LOWER TRUTES TERRACE NEIGHBOURHOOD

28 March 2011

RE: SUBMISSION RESIDENTIAL SUBDIVISION AT FRAZERS DRIVE
TERRANORA REF 09 0166

PLAN SHOWING
PROPOSED SUBDIVISION LAYOUT
& DESIGN CONTOURS

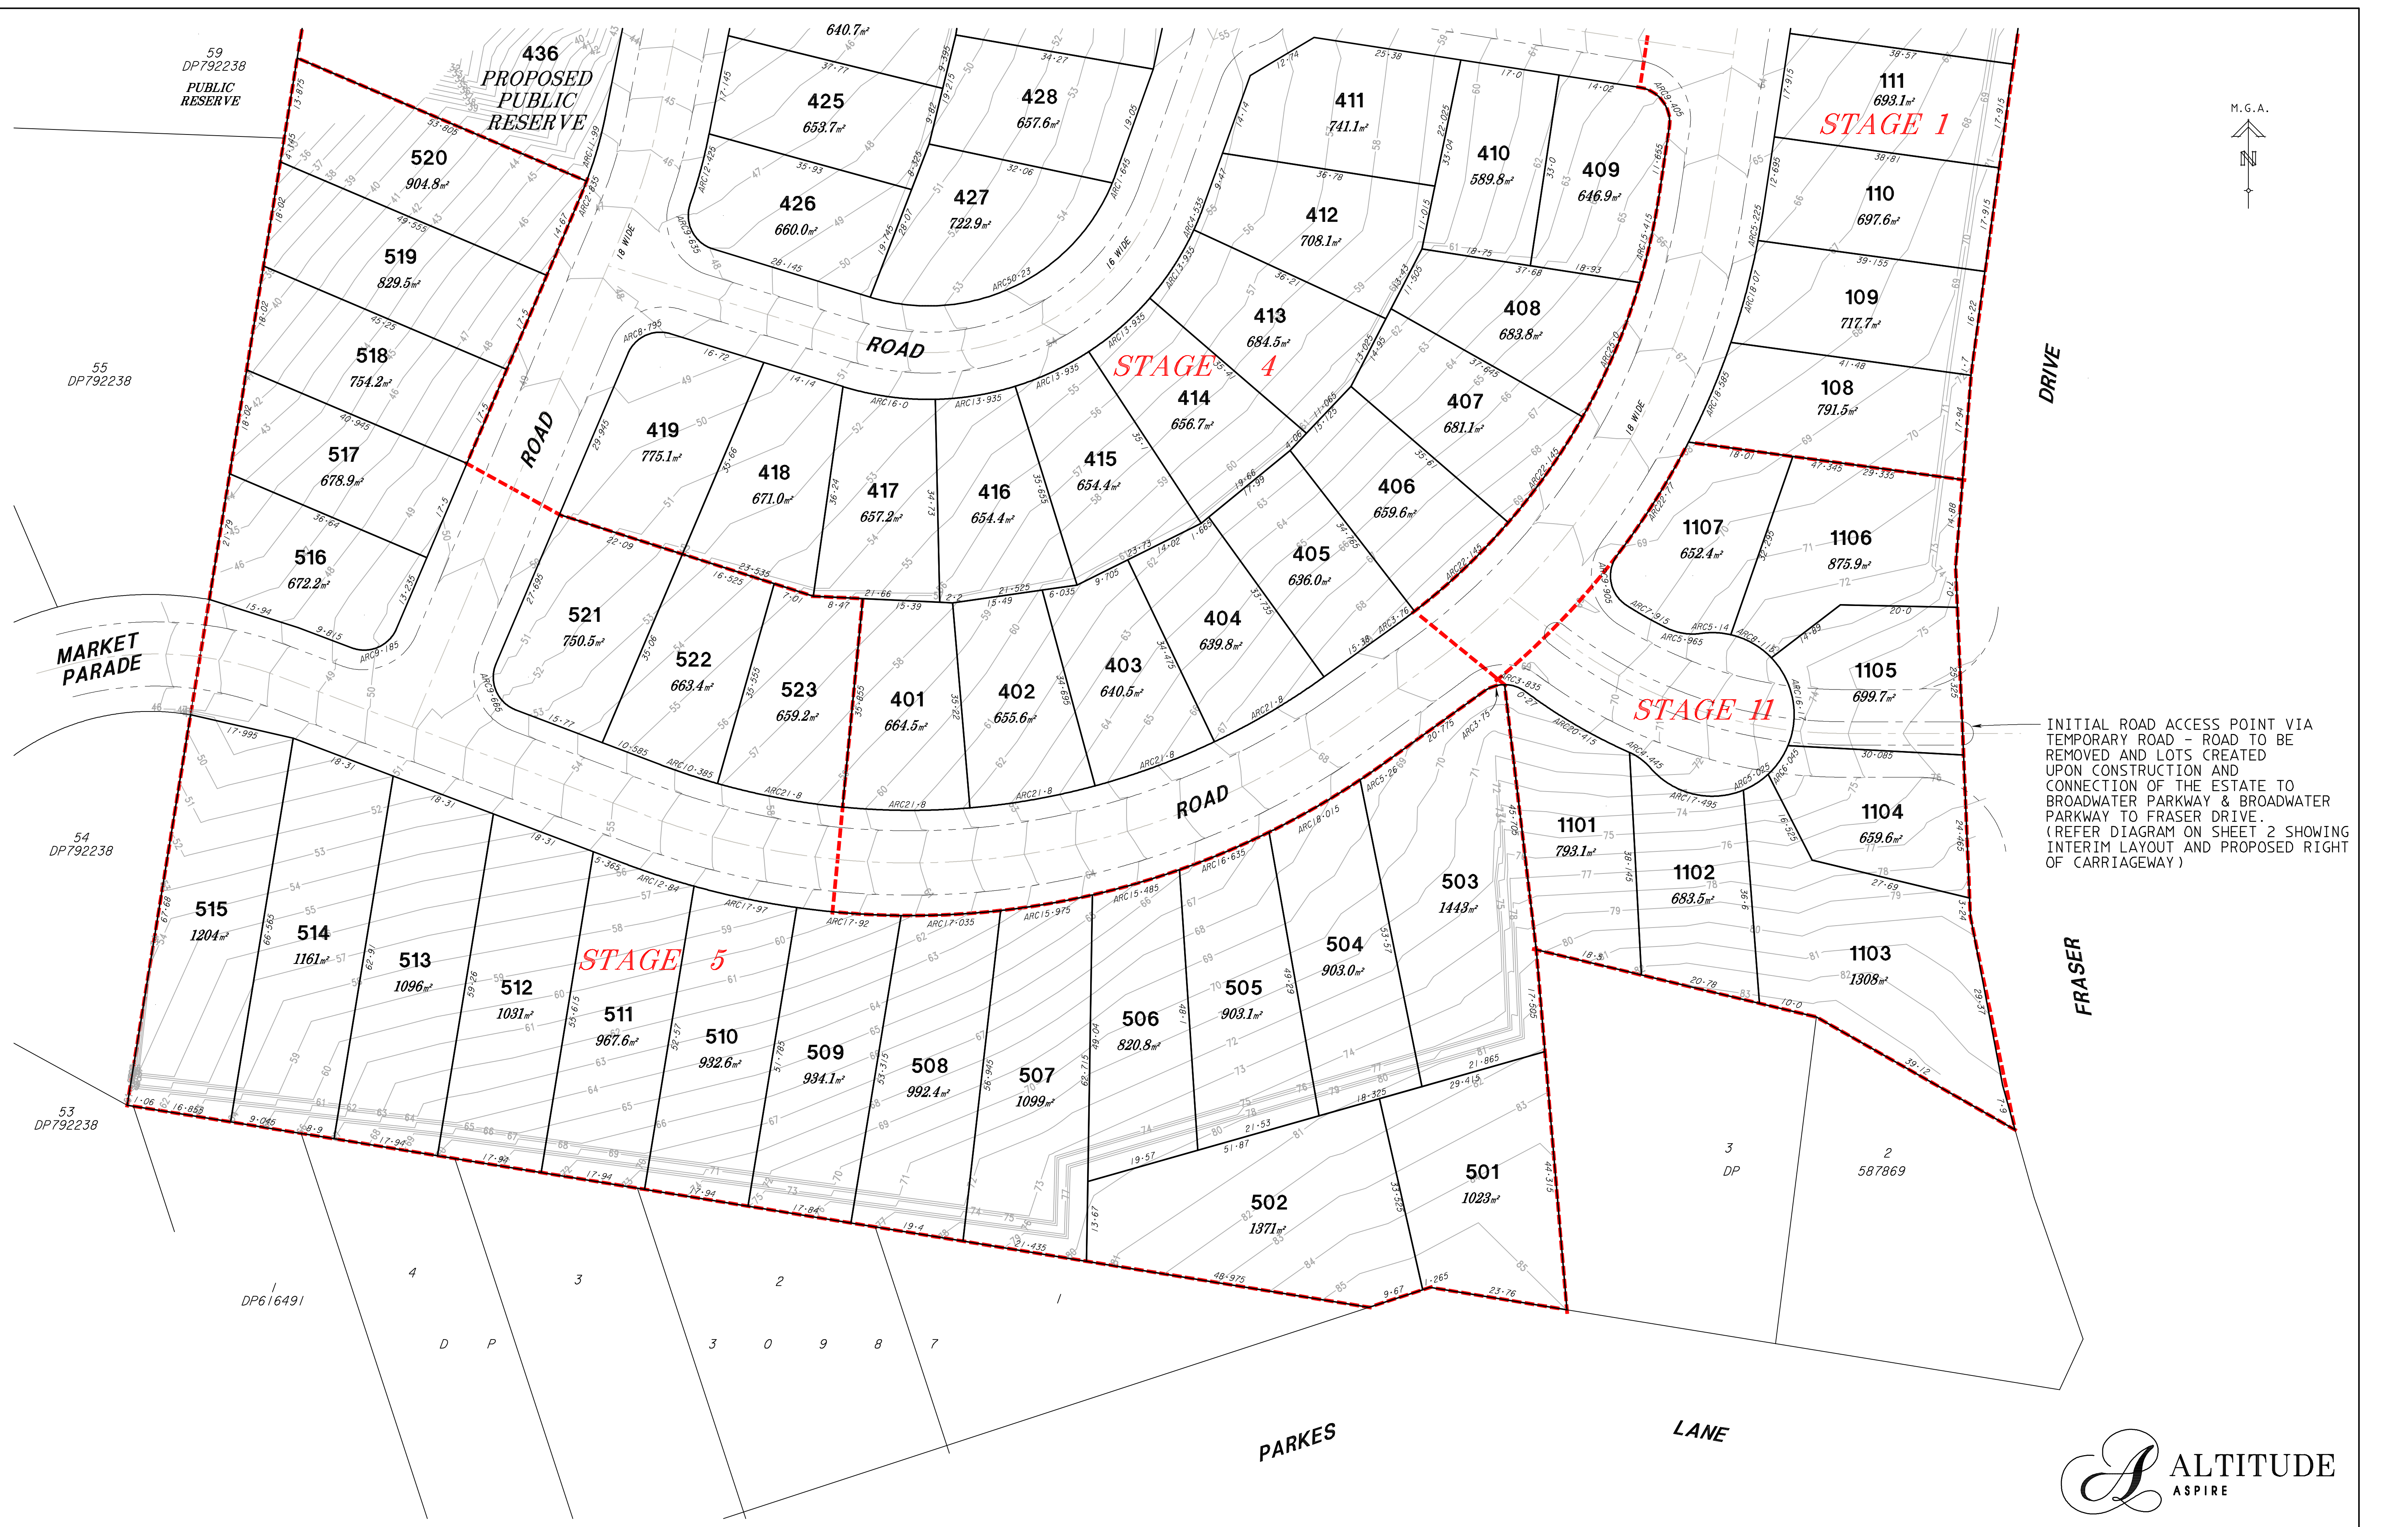
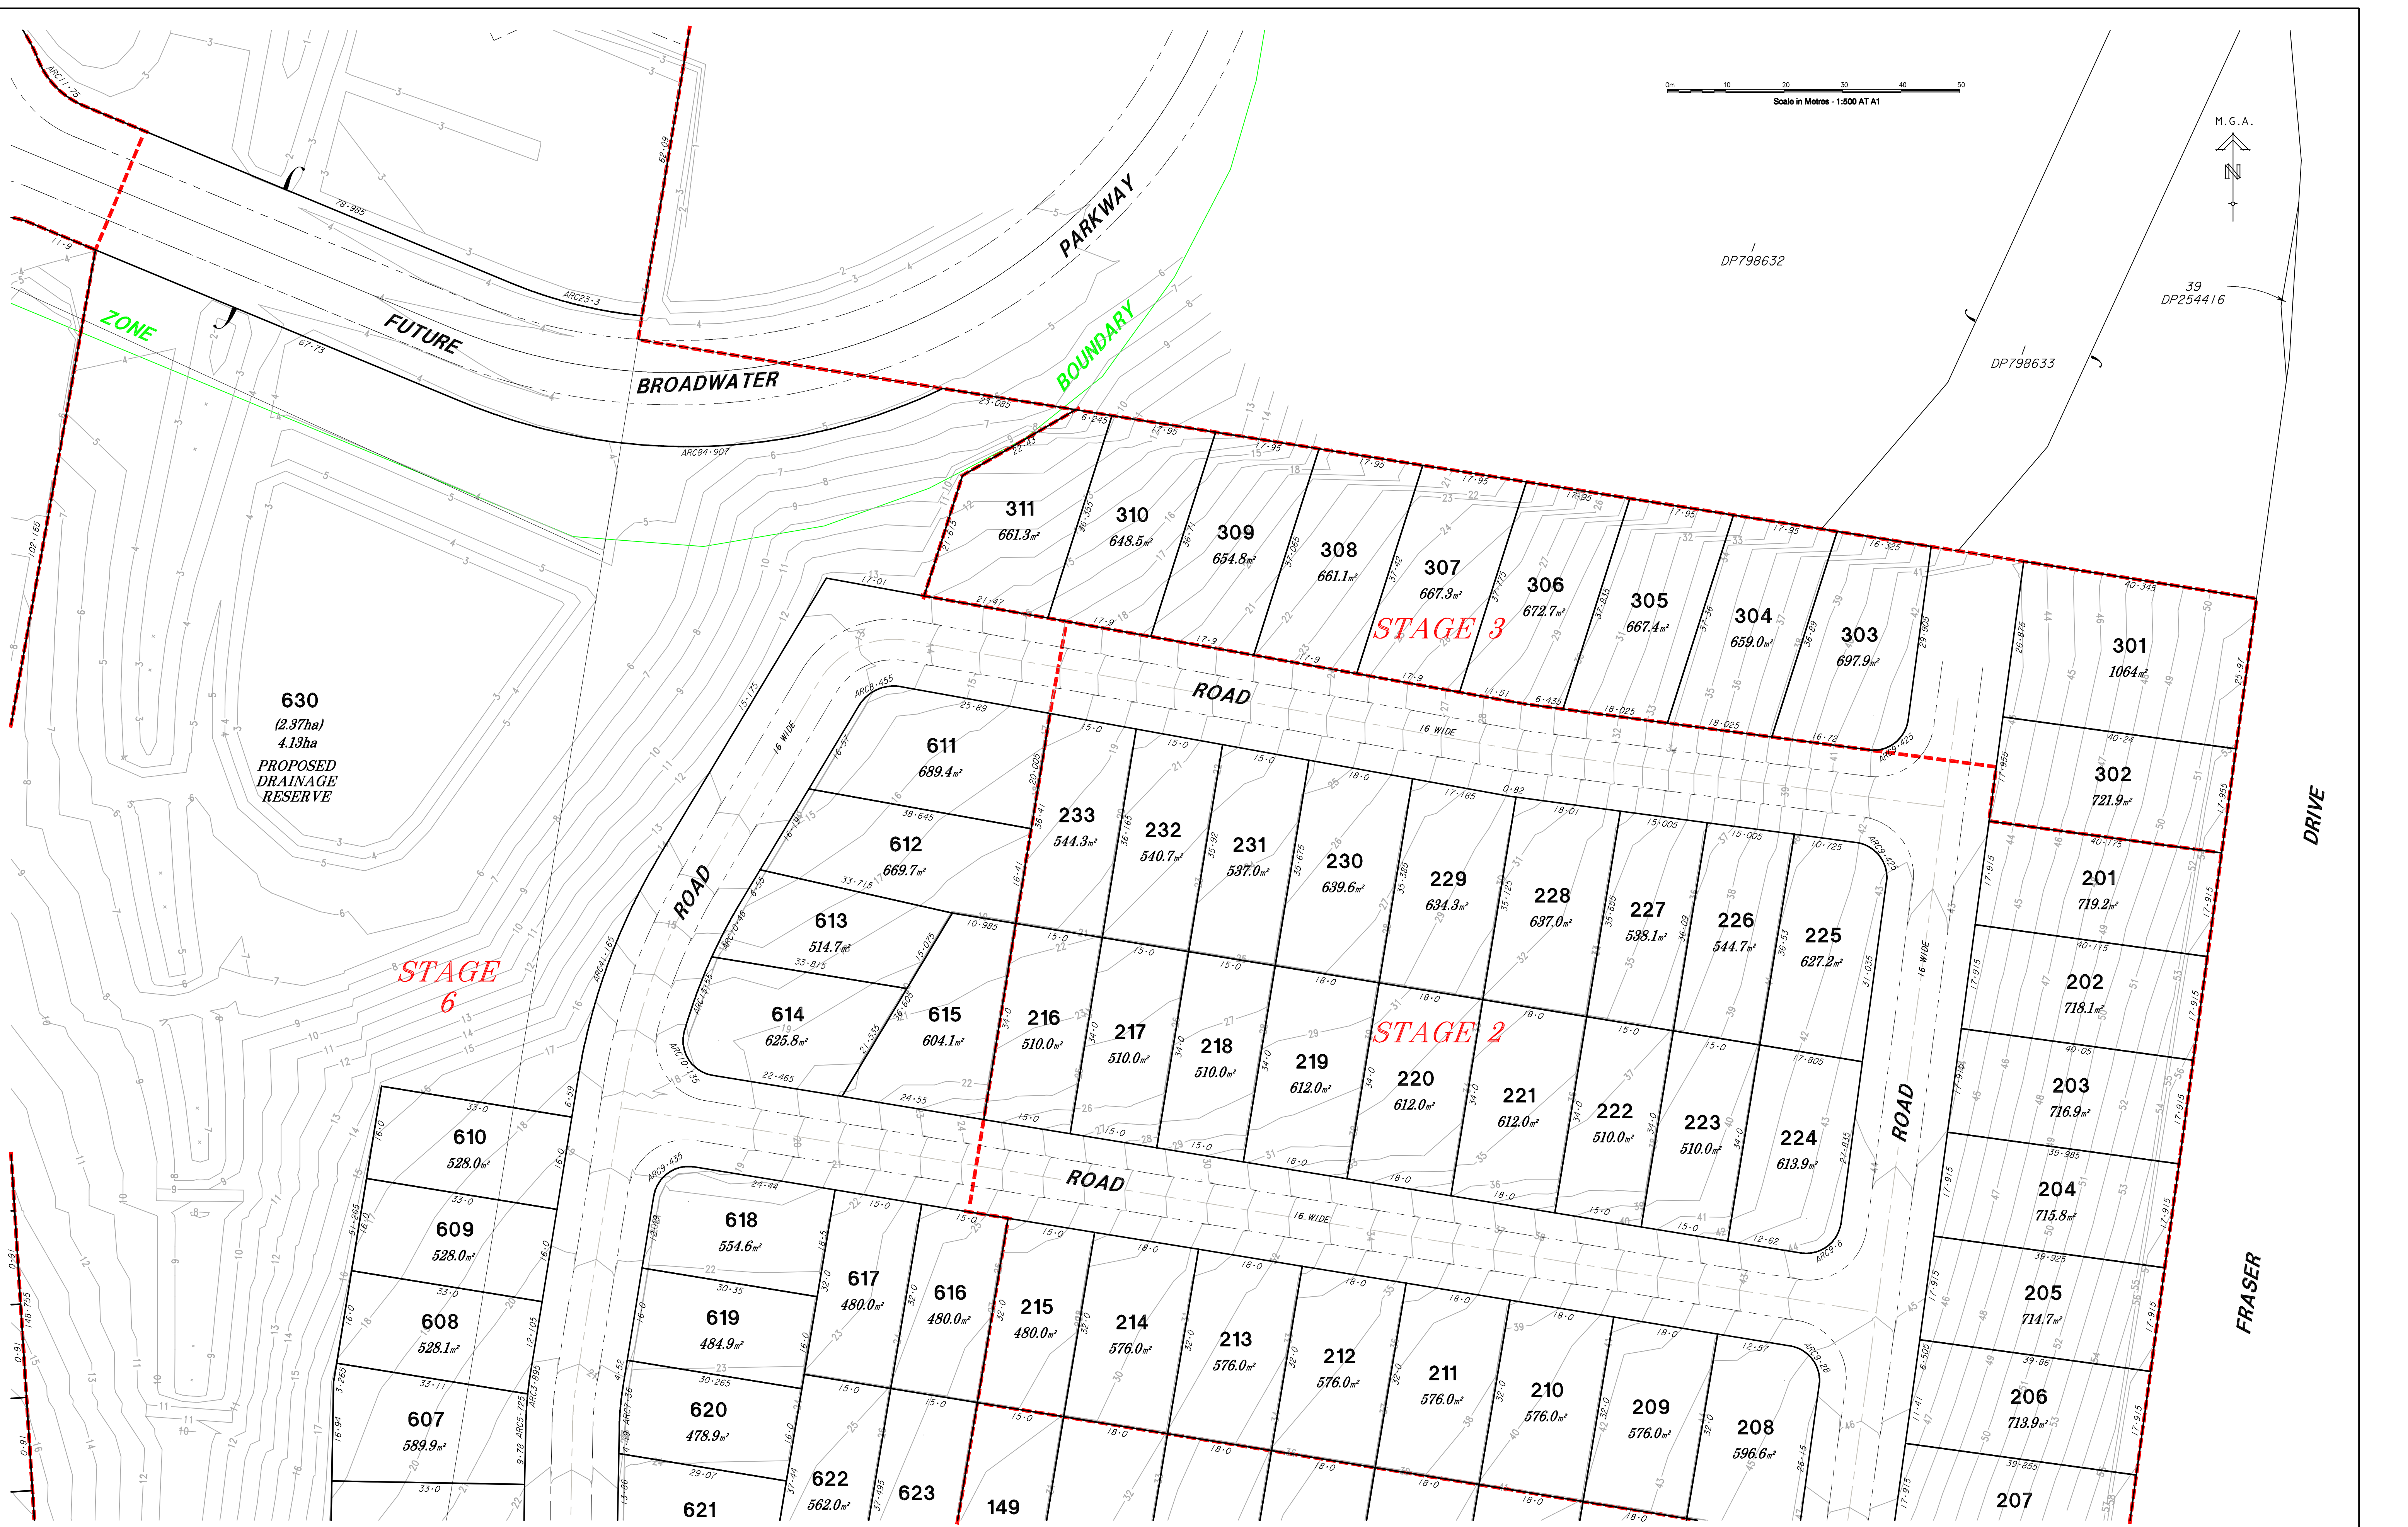
Evidence of this can be seen if you refer to the original subdivision layout that was lodged with State Government in relation to this proposed development. In the original plan lodged, Parkes Lane extended along our common boundary as a shared road and there was a logical road pattern to the left and right.

We now are presented with a plan that see's Parkes Land deviate into this landowners site which immediately puts the timing and ability to access in the hands of this developer and completely beyond our control. This part alone is in our view not equitable to our land or our other neighbour.

In addition while they have maintained a link to Broadwater Parkway they have removed the ability to have a logical connection and road pattern for our eastern precinct. This will force vehicle movements from our site either back up the hill (not efficient) or to the west before they can access Broadwater Parkway where most will head east which is again inefficient.

There is limited access from our land for a secondary access to Broadwater Parkway as we have a number of proposed constructed wetlands to deal with storm water run-off from the greater Area E precinct and the previous shared location was the only opportunity.
